Comments on construction drawings;

Subject: RE: BE/17/20/DOC Site 6 Chichester Road

BE/17/20/DOC – Condition 3 (Surface Water Drainage) and Condition 10 (Facilities to enable Car Charging of Electric Cars)

DRAWING TITLE
SITE LAYOUT - PHASE 4c

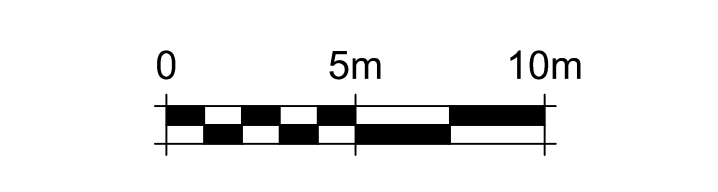
By way of update, EH are checking with their AQ specialist re the revised EVCP plan and the Drainage Officer has responded saying all acceptable, with the exception of point 5 as no construction detail drawing has been supplied.

- EV Charging Layout
- Phase 4C Drainage – 2037/PH4/D/120 Rev H

TITLE:
ON SITE HIGHWAY WORKS
TRAPPED ROAD GULLY POT DETAIL

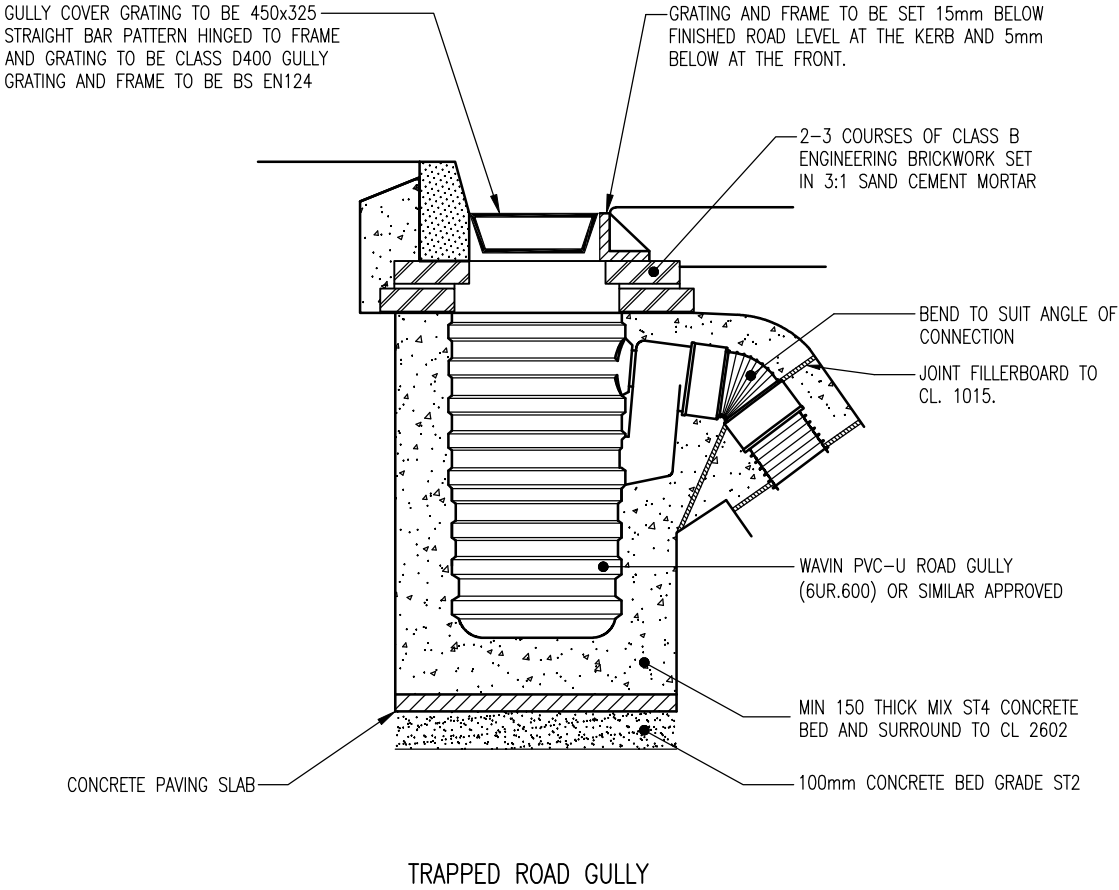
1. Yard gully – specify cover and frame grading.
2. Provide channel drain construction detail (including sump outlet).

Please find construction detail attached, please note that this is as has been approved previously for all preceding phases.
